Application by Fenwick Solar Farm Ltd for an Order Granting Development Consent for Fenwick Solar Farm Project

The Examining Authority's first written questions and requests for information (ExQ1)

Issued on Friday 9 May 2025

**FIGURE NUMBER**  
Figure 8-5-1

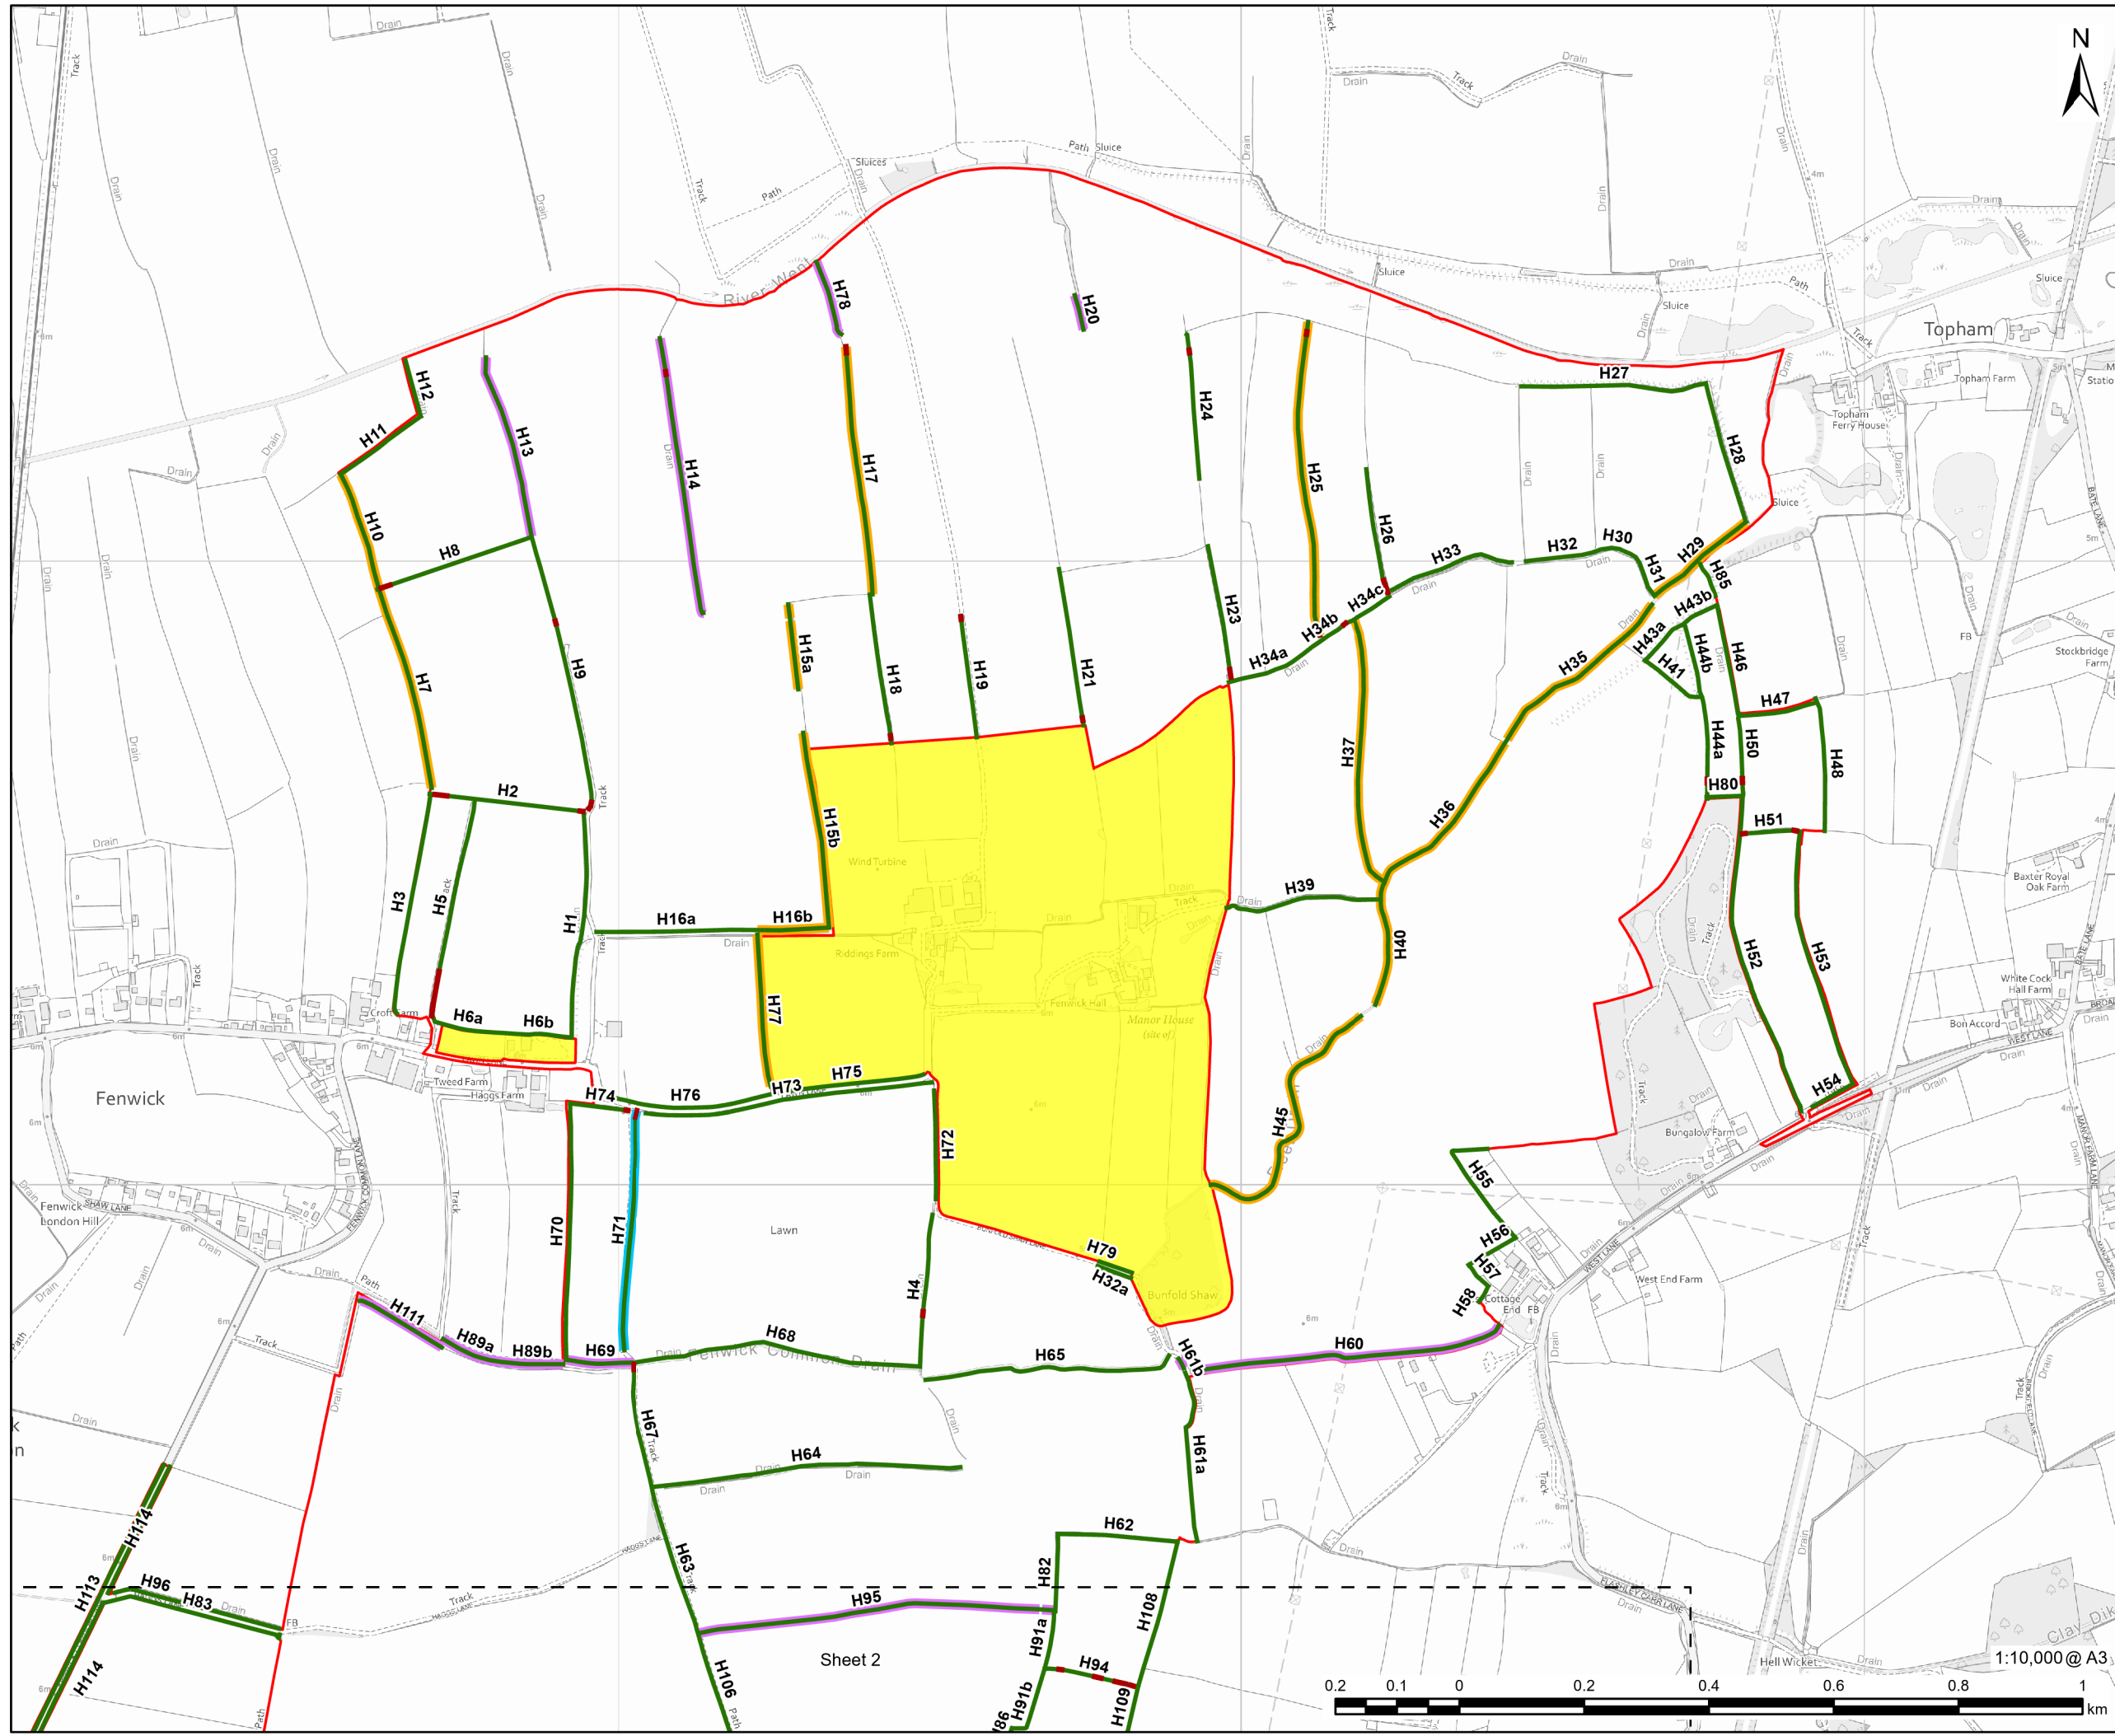
1.6.11	Applicant	Hedgerow Report [APP-150] Figure 8-5-1. Hedgerow H83 and H96 run alongside footpath Fenwick 16 (Haggs Lane). Haggs Lane is identified as the inbound access route for construction workers. Please signpost where within this report or the ES protection measures are proposed for these hedgerows during the construction phase given the need to accommodate both traffic and rights of way users along Fenwick 16.
